St Marys Centre, Grassmere Close, Felpham, PO22 7NU

Conversion of loft space to form new meeting room and insertion of 4 No. rooflights
St. Marys Centre Grassmere Close Bognor Regis

PROPOSED FIRST FLOOR PLAN

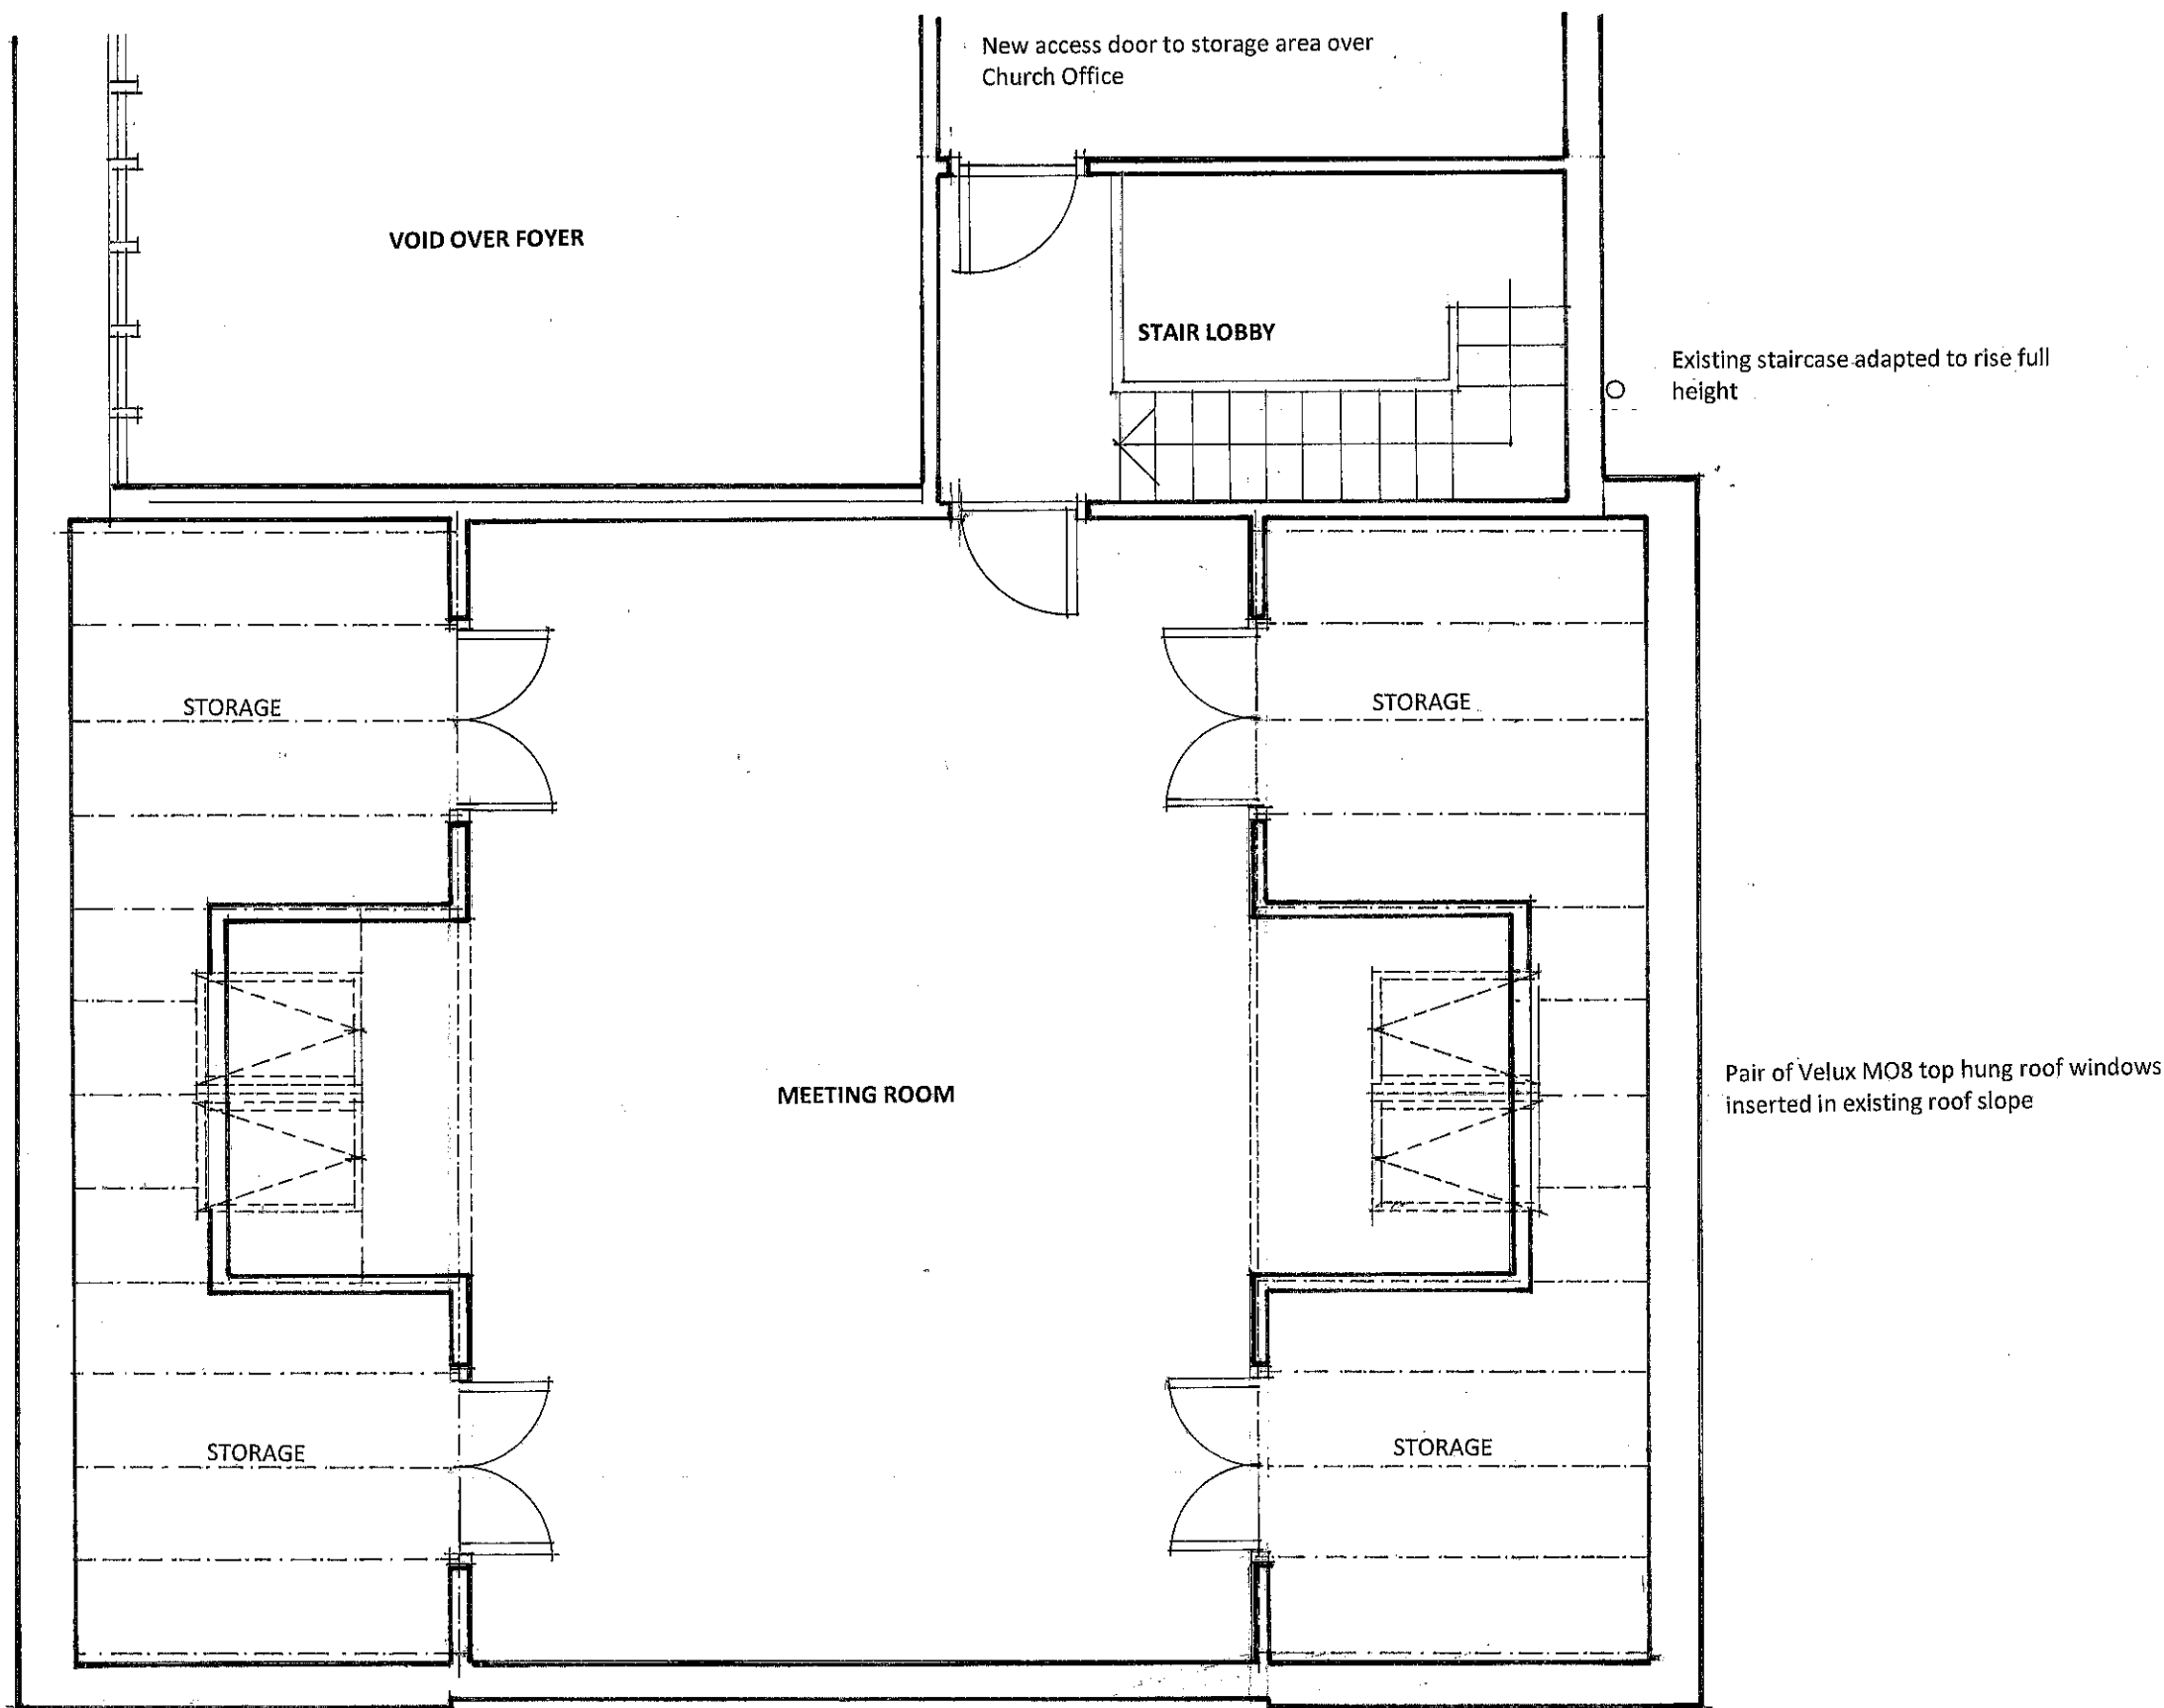
No Objection provided there is no impact on existing tenants in the building. Also as an observation, there does not appear to be any secondary means of escape.
